HIGHWAY AND LEAD LOCAL FLOOD AUTHORITY RESPONSE TO CONSULTATION ON THE FOLLOWING DEVELOPMENT PROPOSAL

Application number: H18-0879-25

Proposal: Erection of 8 dwellings - outline with access to be considered

Location: Land adjacent 39 Custom House Street, Sutton Bridge, Spalding, Lincolnshire, PE12 9UJ

Drawing
 SITE PLAN - EXISTING & PROPOSED
 LOCATION PLAN

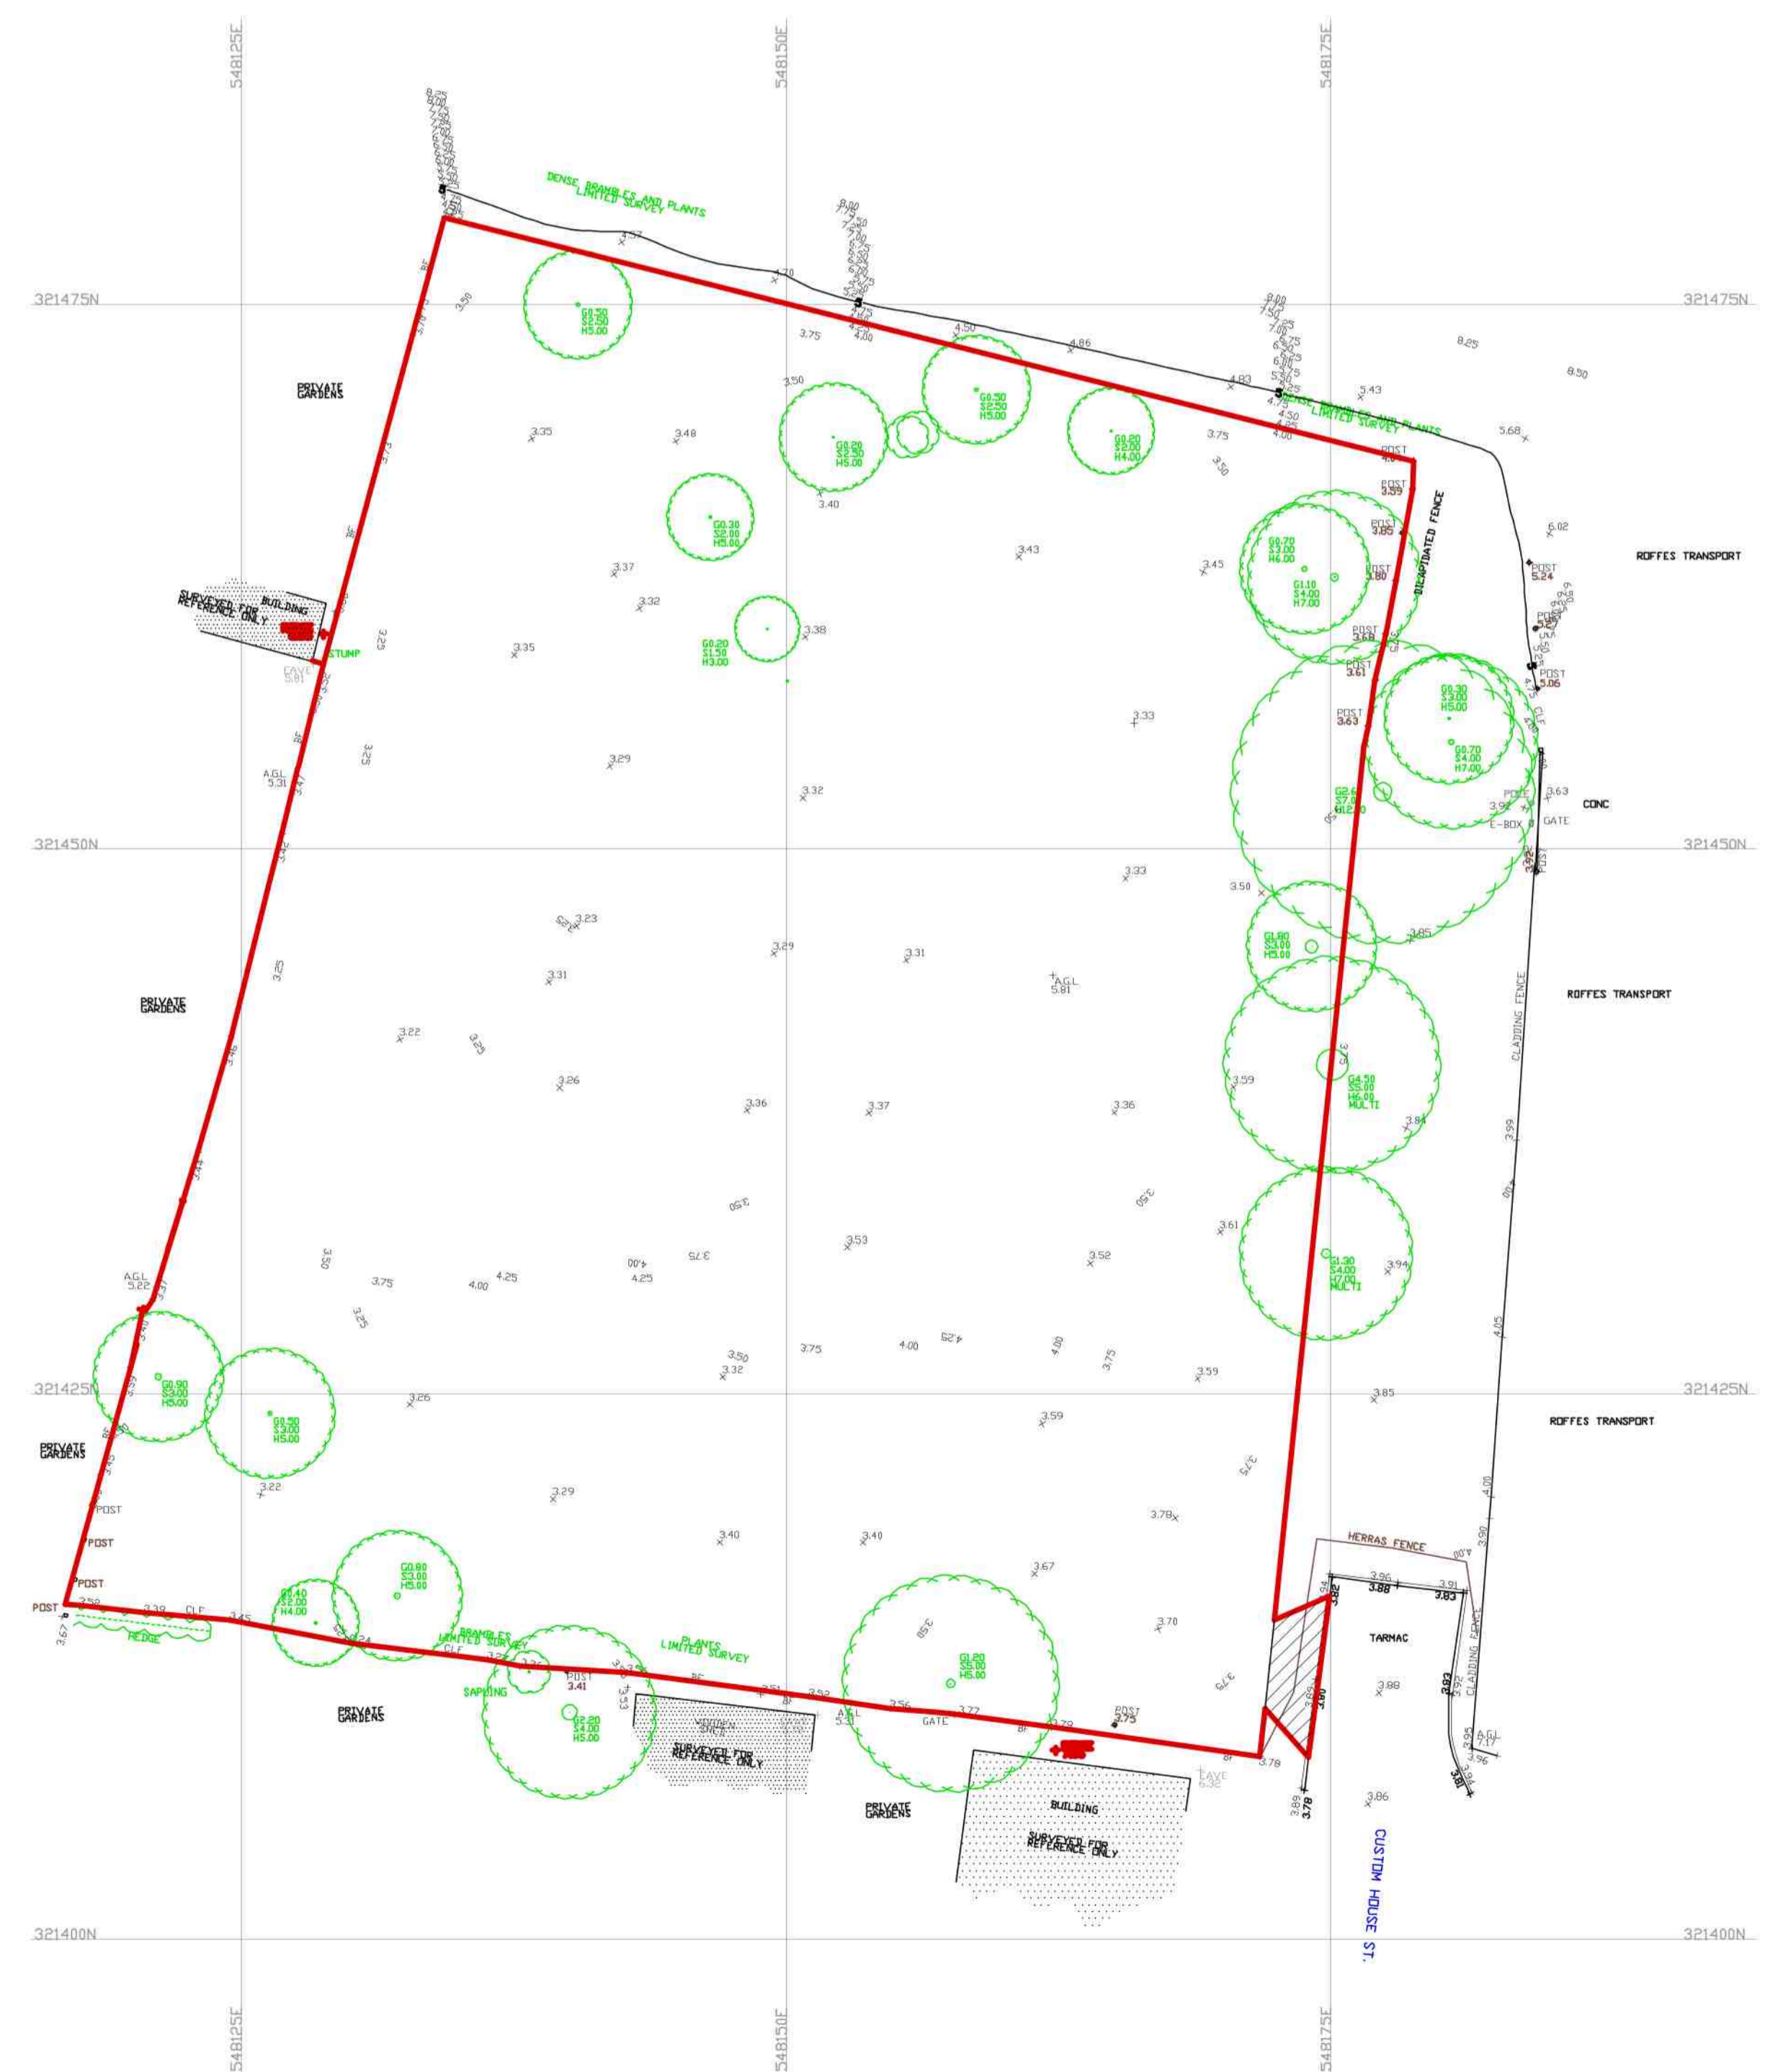
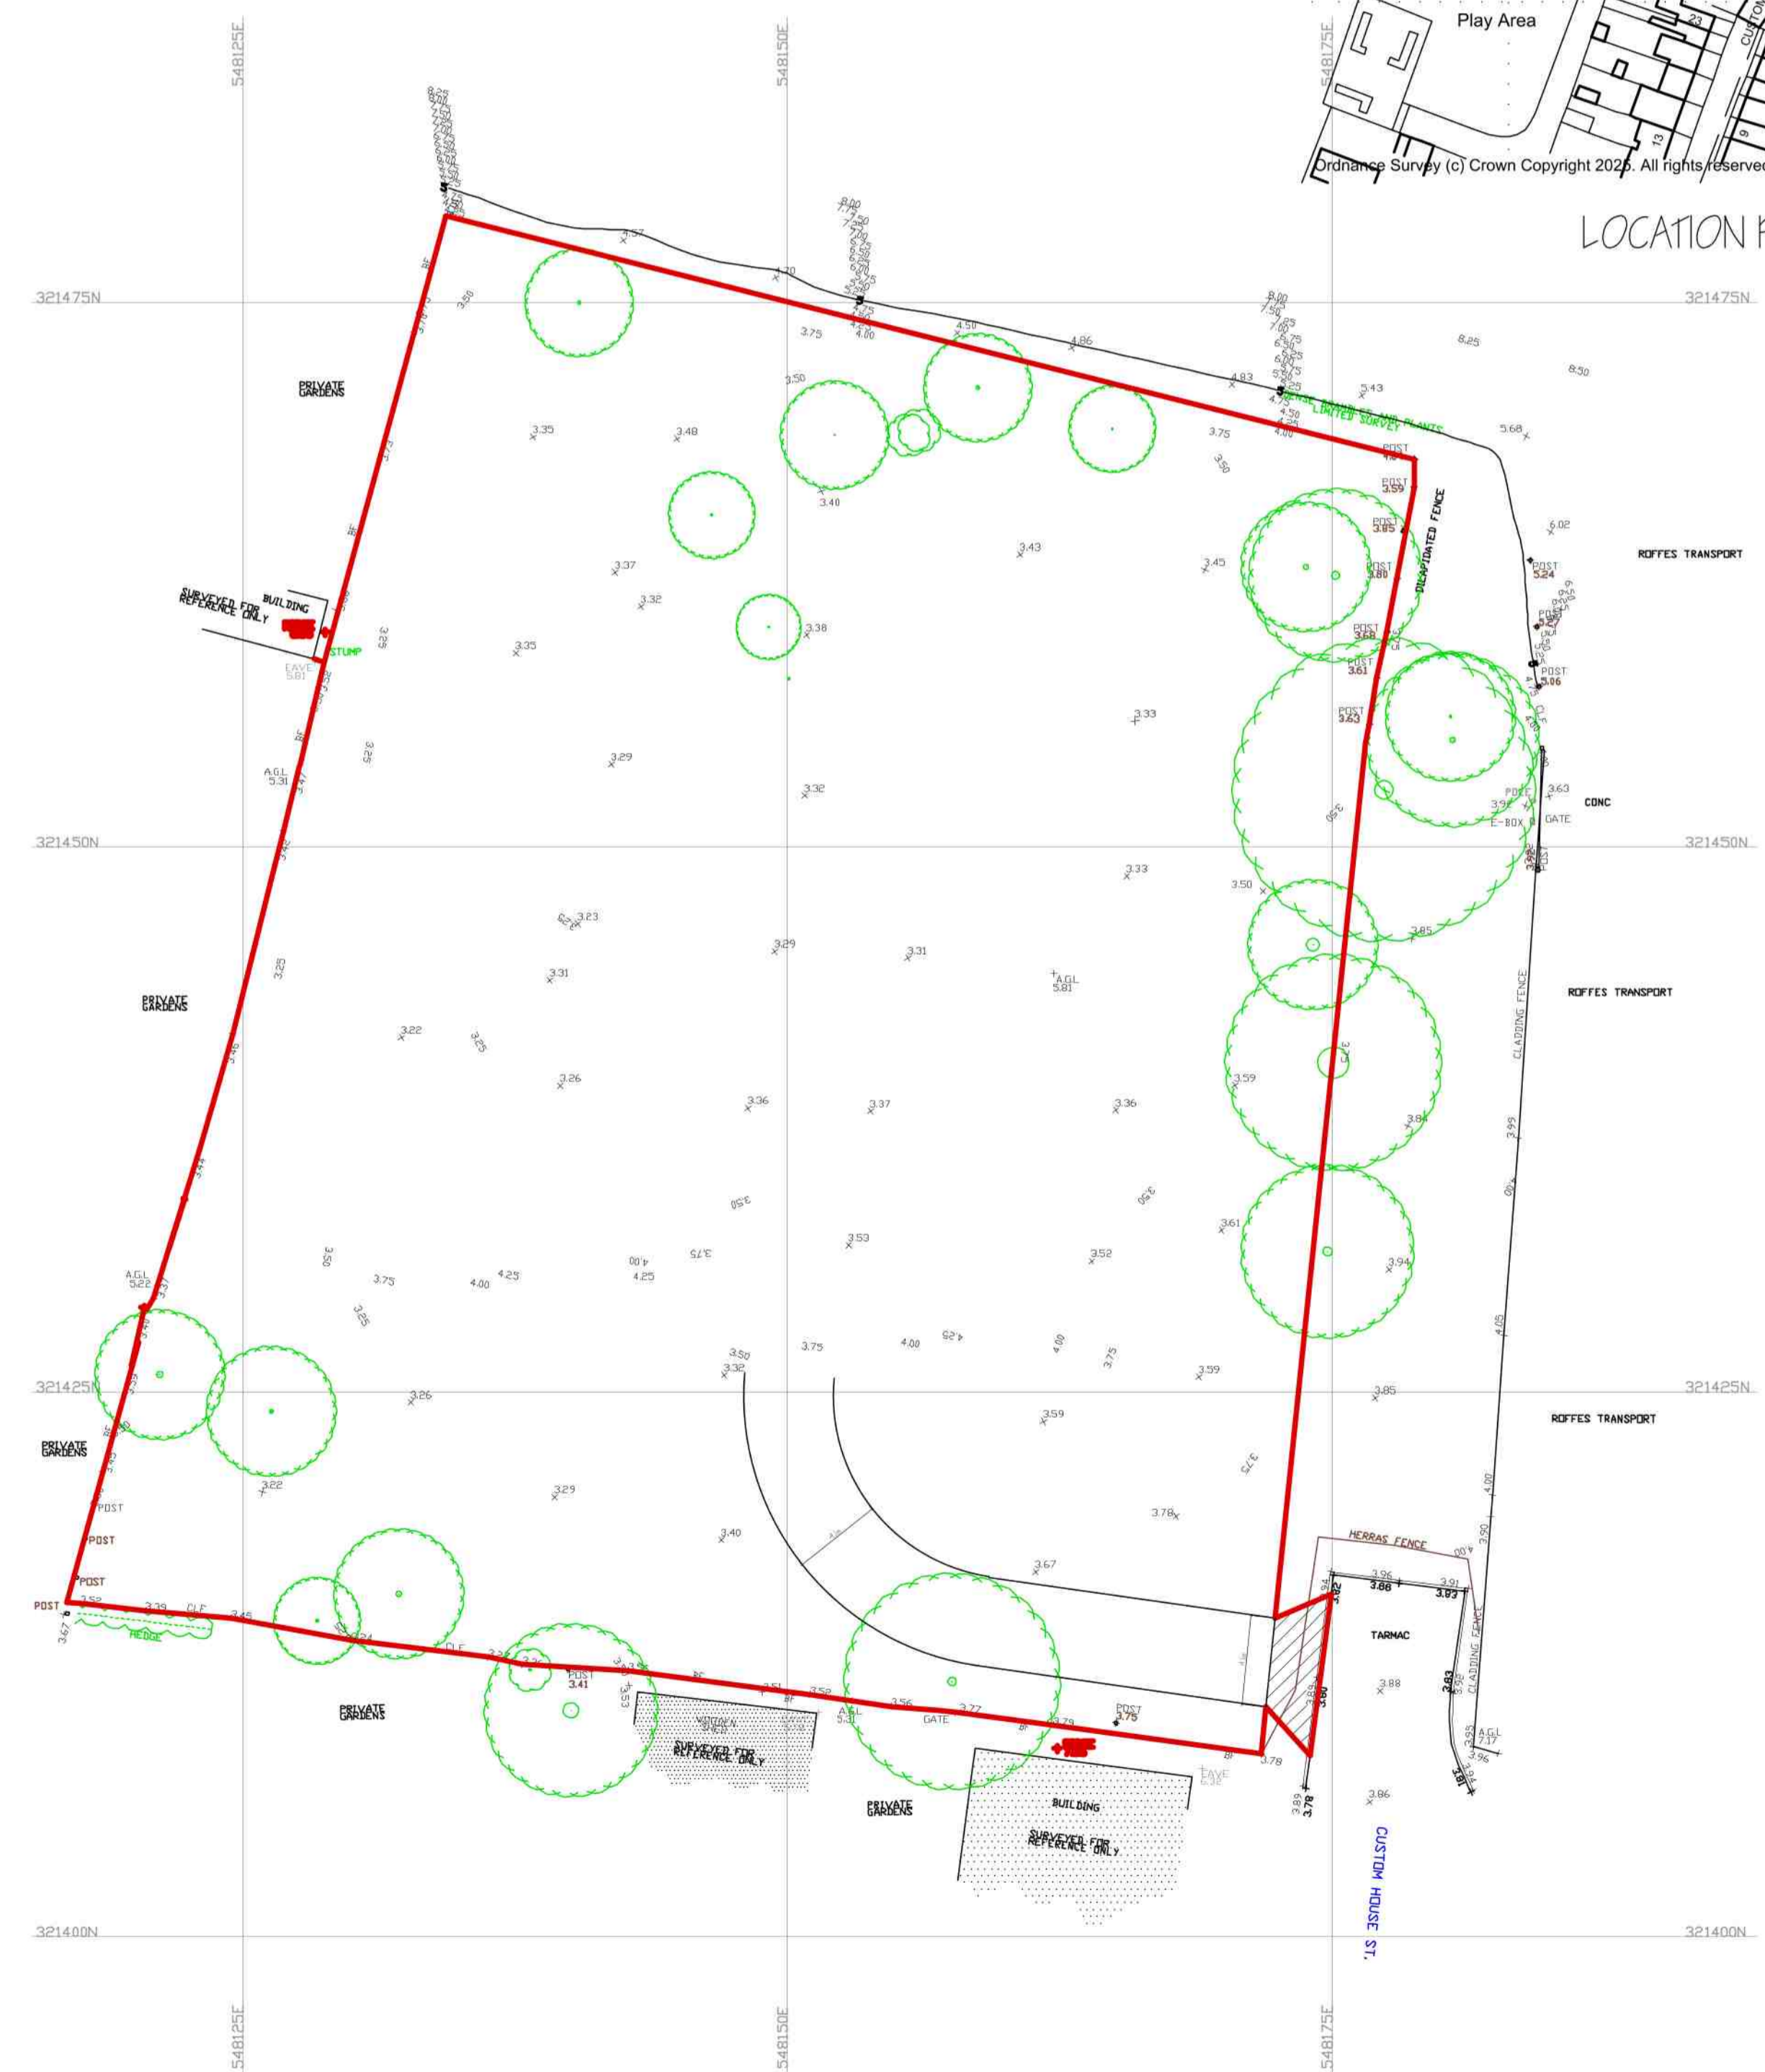
The proposal is for the erection of 8 dwellings - outline with access to be considered. The site will be accessed from Custom House Street cul-de-sac which is an established residential area. Access from this point for the proposed 8 dwellings would be acceptable – this will be a private drive and will not be adopted in the future. A footway connection is required from the site access to the existing on Custom House Street to ensure pedestrian connectivity is maintained. When a reserved matters application is being prepared consideration should be given to refuse collection points as a refuse vehicle will not enter a private drive. The width of the access with the public highway shall be a minimum of 4.5m wide for the first 10m and thereafter it shall be 3.7m. The proposal will not have an adverse effect on the public highway.

No part of the development hereby permitted shall be occupied before the works to improve the public highway (by means of a frontage footway connecting to the existing) have been certified complete by the Local Planning Authority.

HP11A – Prior to first occupation on site further details relating to the vehicular access to the public highway, including materials, specification of works and construction method shall be submitted to the Local Planning Authority for approval. The approved details shall be implemented on site before the development is first occupied and thereafter retained at all times.
